ELLICOTT SAND AND GRAVEL LLC - SITE DEVELOPMENT PLAN

STAGE 1 OF 6 - SITE DEVELOPMENT PLAN - PPR234

EL PASO COUNTY SITE DEVELOPMENT PLAN
SITE DEVELOPMENT PLAN NOTES PAGE
FOR
SCHUBERT RANCH SAND RESOURCE
ELLICOTT, COLORADO

Figure 13  
**WB-40 AutoTurn Movements &  
Access Design Recommendations**

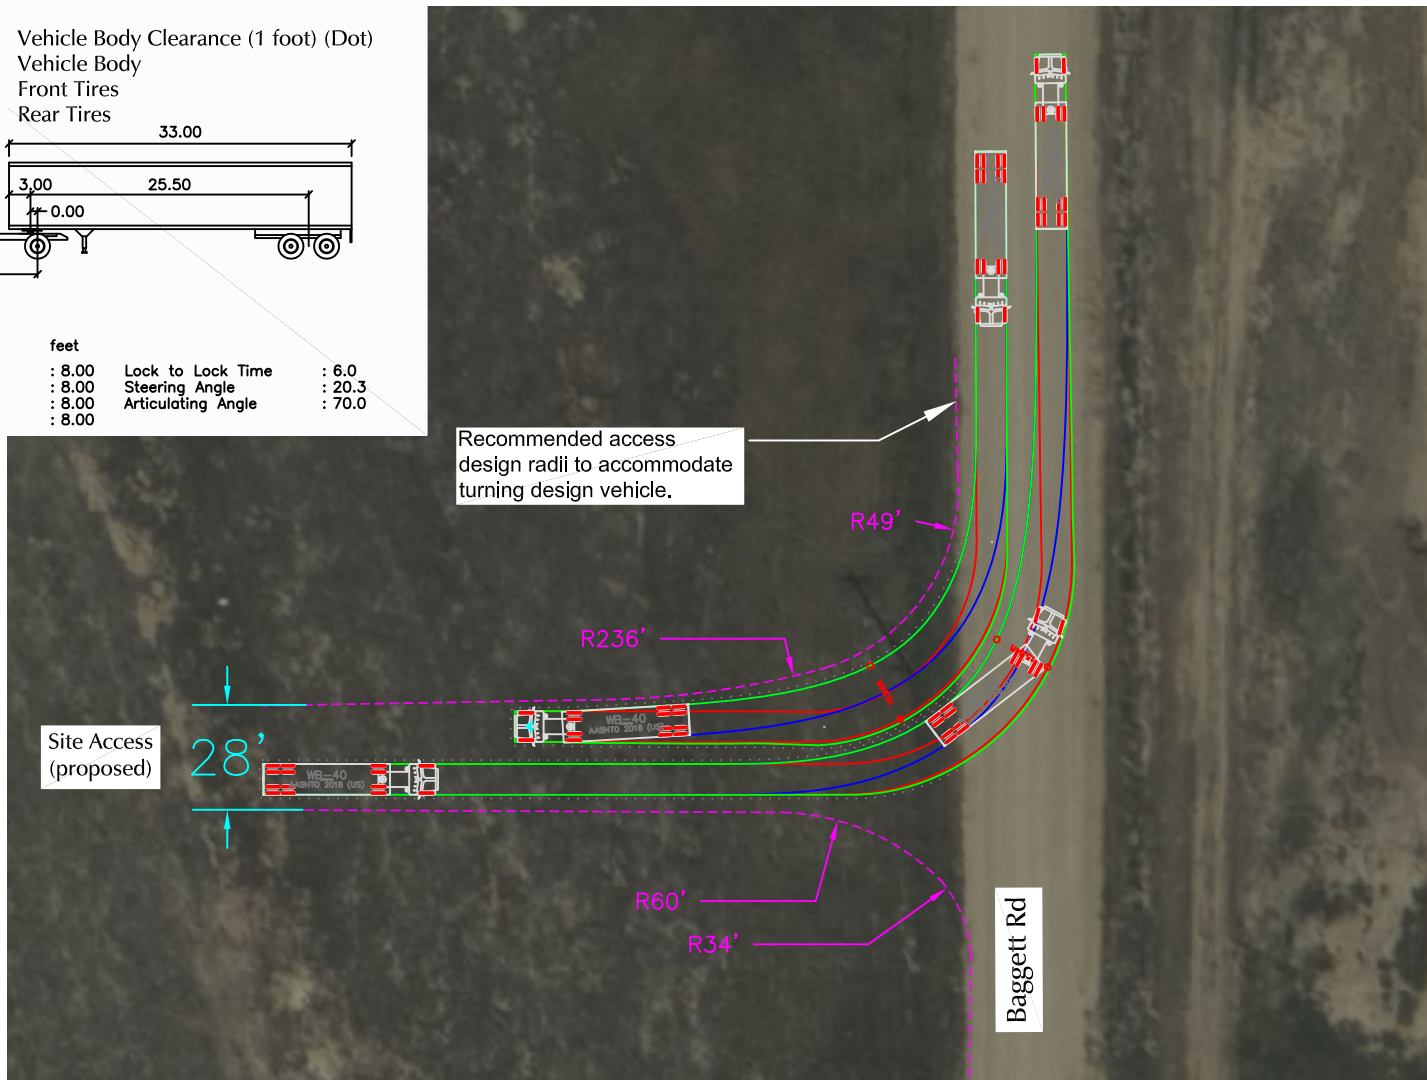
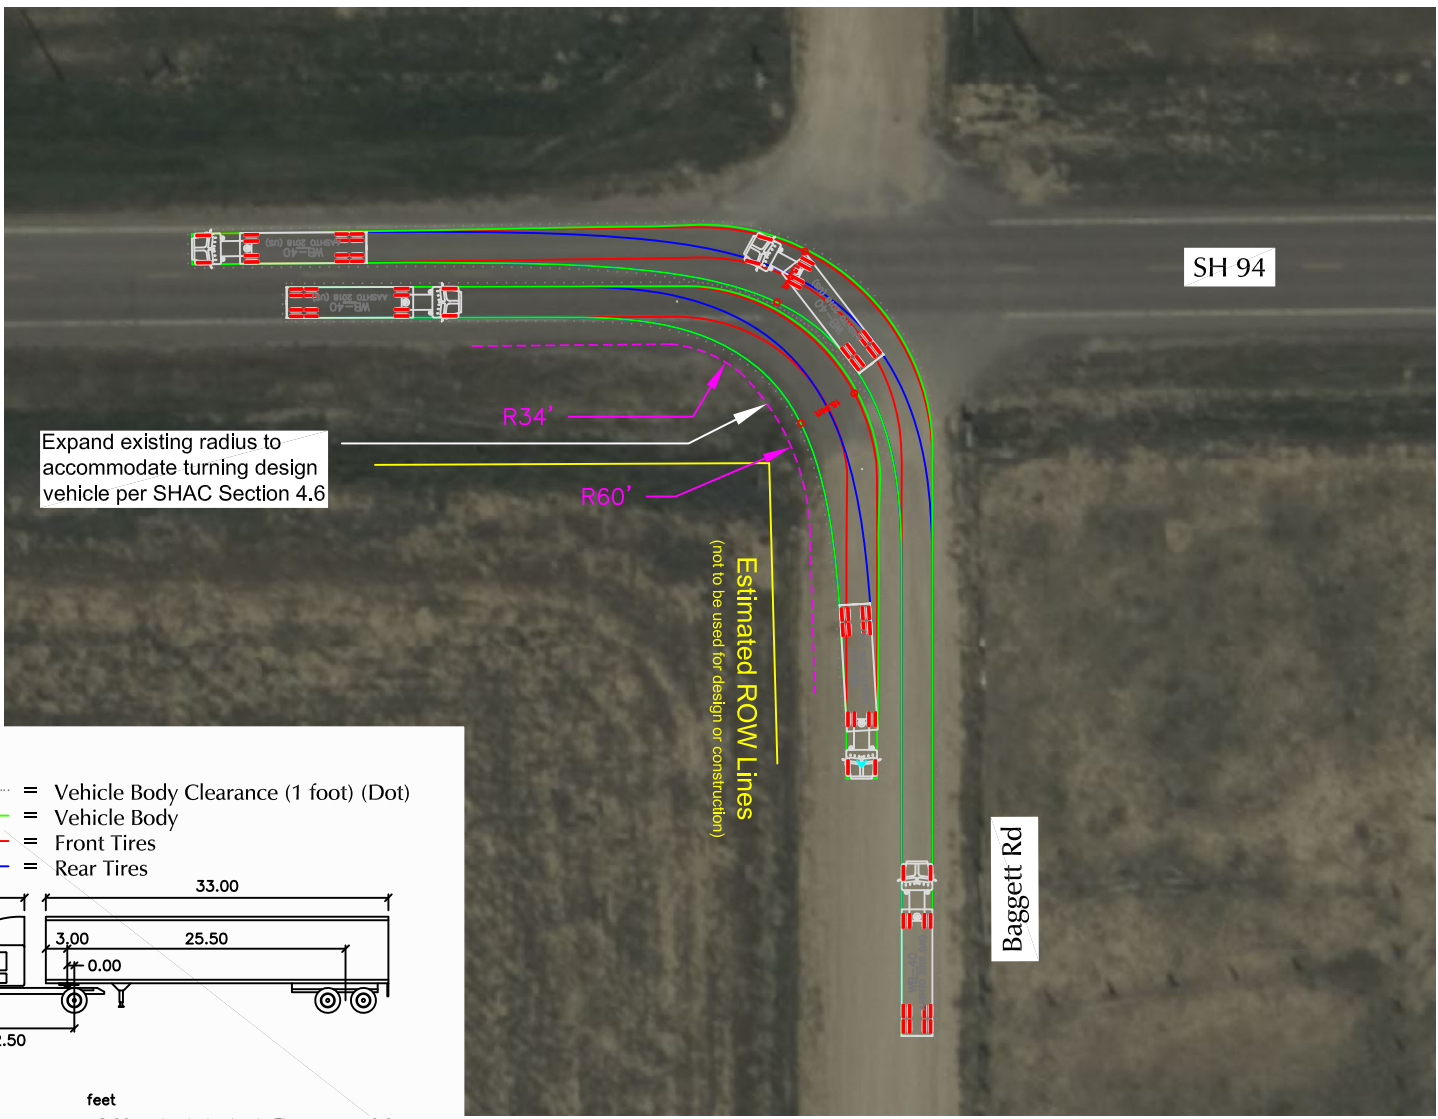
- Appropriate turning radius is needed for the design vehicle. Please depict on the plans. Per the traffic study provided with the special use application it was identified that an Autoturn analysis along with recommendations would be provided at this site development stage. Please update the TIS to provide recommendations.
